**APPLICATION BY MONA OFFSHORE WIND LIMITED FOR AN
ORDER GRANTING DEVELOPMENT CONSENT FOR THE MONA
OFFSHORE WIND**

**PLANNING INSPECTORATE REFERENCE NUMBER
EN010137**

SUPPLEMENTARY WRITTEN REPRESENTATIONS

**Document Reference S_D1_5.6 Document No. MOCNS-J3303-RPS-10277
entitled Appendix to Response to Hearing Action Point: Indicative onshore
cable corridor crossing section and trenchless technique crossing long-
section**

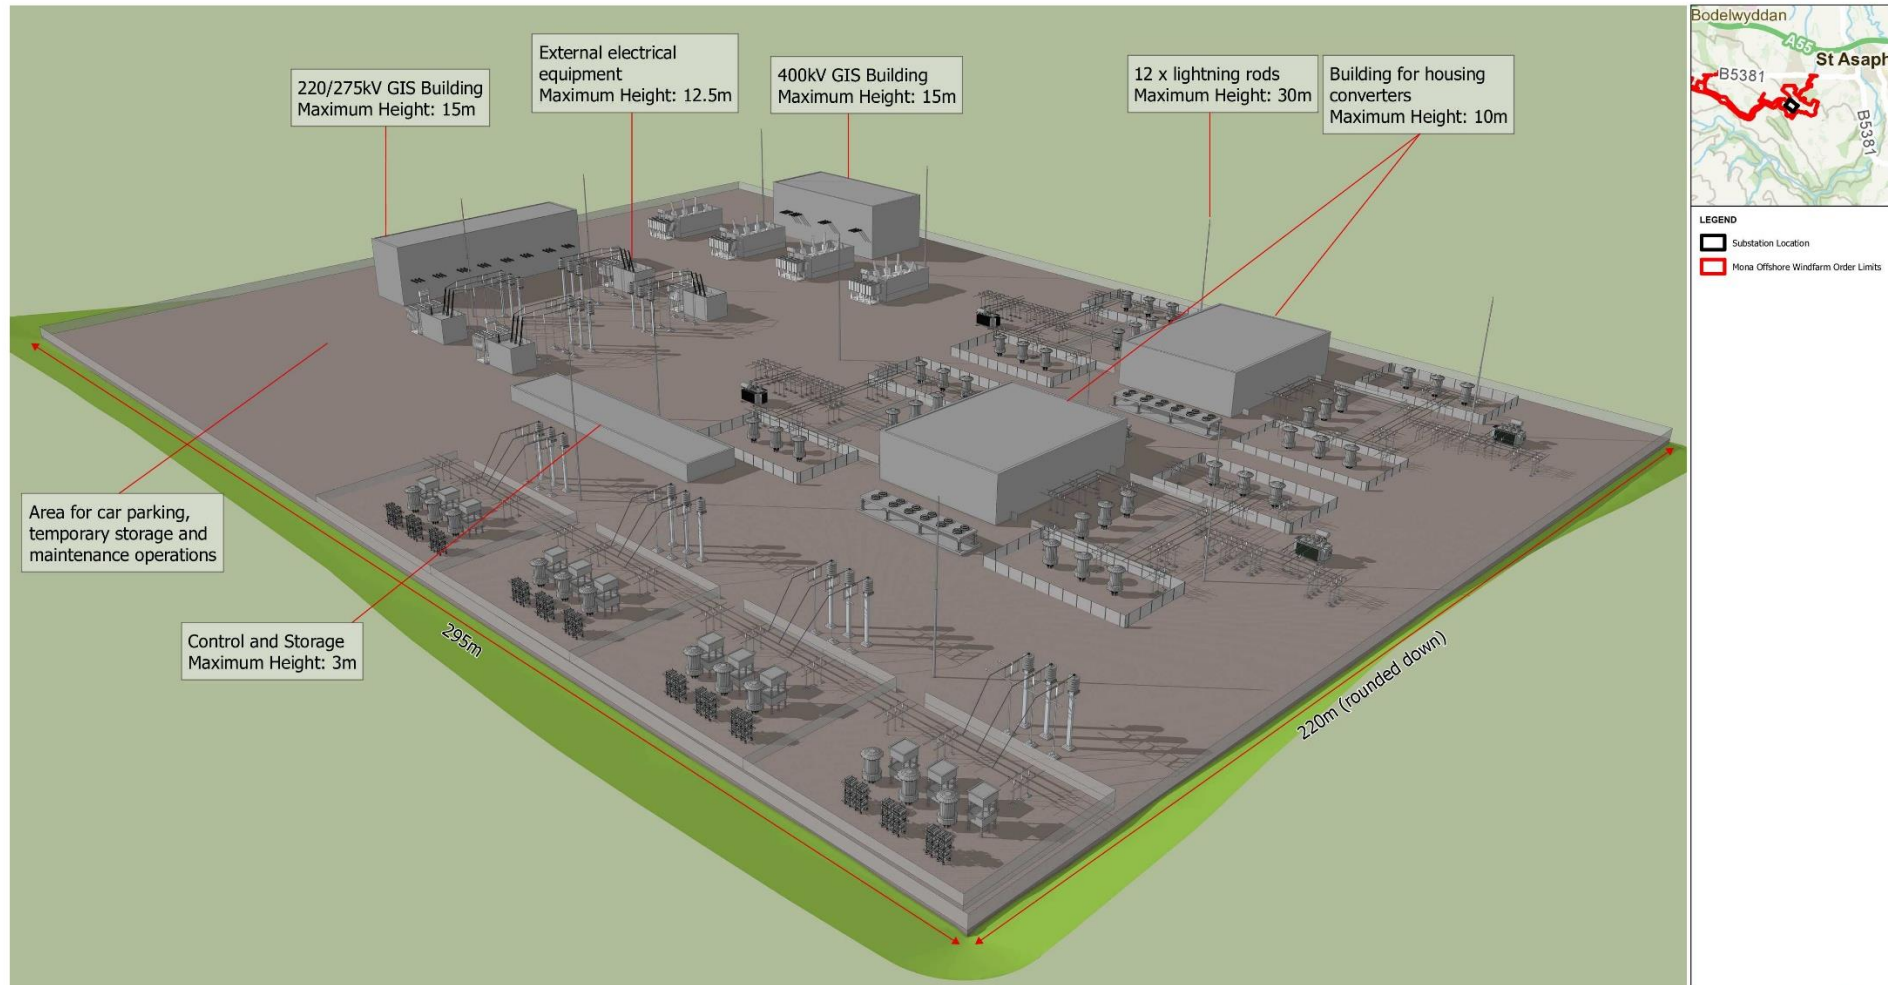
- 3.6 Despite the health and safety risks, the Promoter does not propose trench support and instead seems to be seeking to use an excessively wide 2.5M wide trench to accommodate angled slopes to be excavated to the depth of 1.8m in readiness to receive trench support material. See diagram extract from the Drawing in the Promoter’s Hearing Action Point Submission:

- 3.7 The drawing is clearly marked “not to scale” and so the Promoters proposed angulation for the excavation cannot be reliably measured. There also seem to be some discrepancies with the Promoter’s vertical measurements on the diagram which make calculating the angle a little more difficult. Nevertheless, with some margin for error, the angle has been estimated to be approximately 52.5 degrees from the horizontal.

- 3.9 Nevertheless, based on the standard arrangement described in the Hearing Action Point Submission, it can be seen that after the first 1.275m of the trench walls will be battered at an angle of approximately 52.5 degrees. This causes the open trench area to extend to a width equating to an additional 1.95m over what is strictly necessary to accommodate the cables which is namely the 0.55m at the very bottom of the trench with the angulation entirely unnecessary.

- 3.10 Notwithstanding the health and safety risks, this gives rise to a great deal of additional excavation and material arisings than would otherwise be required and this is calculated in the markup below:

3.19 The Promoter's cross section Drawing in the Hearing Action Point Submission shows a 10 metre topsoil bund together with an 8.6 metre subsoil bund at both sides of the proposed trench excavations . No measurements are given for the bund heights and they cannot be scaled as the drawing clearly states that it is "not to scale"

- 3.34 We must therefore again conclude that there are no thermal or EMF reasons for the 5M width between trenches and we must therefore again assume that it is instead for "**ease of**" construction or "**ease of**" maintenance reasons.
- 3.35 In terms of construction a standard 12 tonne tracked excavator has a width of approximately 2.55m wide. This itself is slightly more than the trench width that the Promoter intends to utilise.
- 3.36 Two excavators have therefore been shown overlaid on the Drawing below:

3.43 Two such tipper wagons have therefore been shown overlaid to on an extract from Drawing below which shows that the road can conveniently accommodate two way Heavy Goods Vehicle traffic:

3.46 The Promoter could consider a 3m haul road with passing places but has chosen not to do so.

3.47 Better still, the Promoter could install a 3m haul road with passing places directly adjacent to the first trench in which all works would be completed and backfilled in full before the haul road is moved away from the completed trench and the second trench commenced which would be located in the original footprint of where the haul road was previously located for the first trench. Repeating this for trenches 3 and 4 would mean a much more efficient use of the land and the at the end of construction the final location of the haul road footprint could accommodate the final post construction drainage.
